The proposal is for the change of use from an office building to a 2 bed dwelling at the above address. Lidsey Road is an 'A' classified road with a 50mph speed limit in this location.

APPLICATION AL/44/17/PD

Registered: 3rd April 2017
Site Address: Lidsey Barn Lidsey Farm Lidsey PO22 9PG

Description of Works: Prior Notification for a change of use of a building from office use (class B1(a) to a dwellinghouse (Class C3)

Drawing: Block plan (1:500 @ A3)

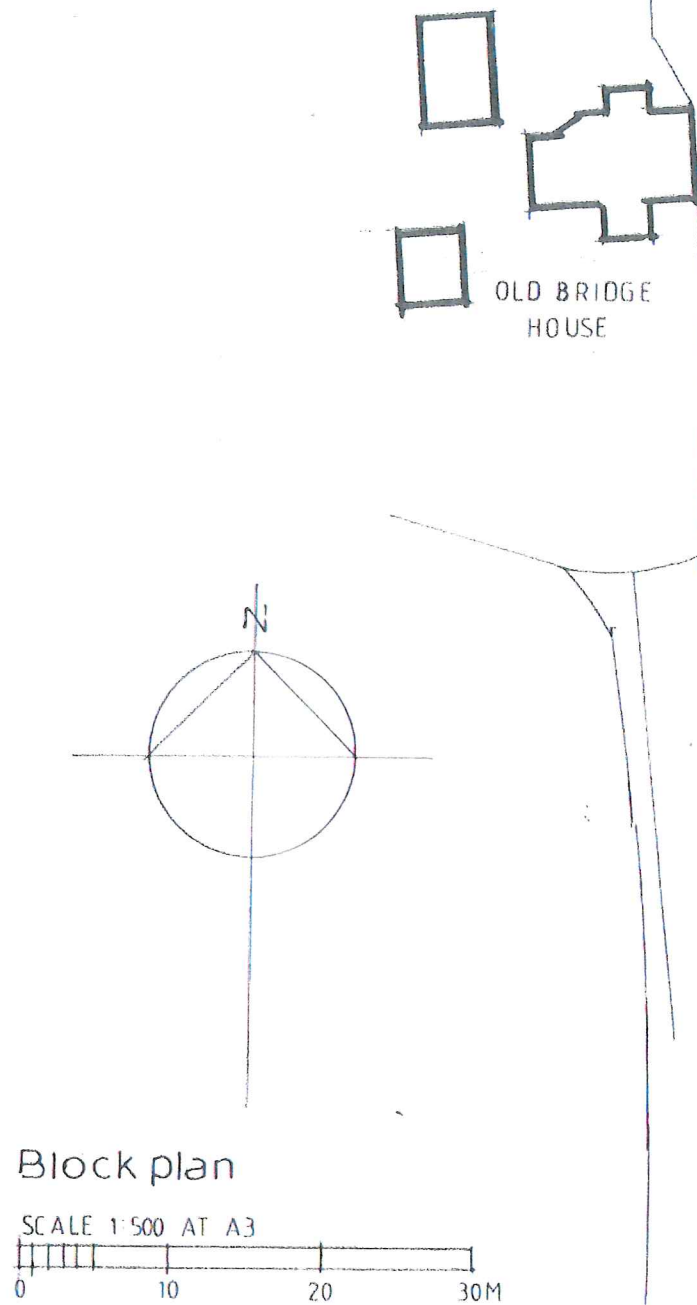
A study of the block plan demonstrates that the dwelling will share an existing access off Lidsey Road which also serves light industrial buildings to the rear of the site. There are no alterations proposed to the access which has adequate visibility in both directions onto Lidsey Road. The Local Highway Authority (LHA) has reviewed data supplied to WSCC by Sussex Police over a period of the last five years. There have been three recorded injury accidents in the vicinity, however, these accidents were not related to highway safety issues and there is no evidence to suggest that the local road network is operating unsafely, or that the proposal would exacerbate an existing safety concern.

The prior notification process does not enable parking provision to be considered. Nevertheless, the block plan establishes that two parking spaces are to be provided as part of this development. This is in accordance with the WSCC Parking Demand Calculator. Sufficient turning space is to be provided, enabling a vehicle to exit the site in a forward gear.
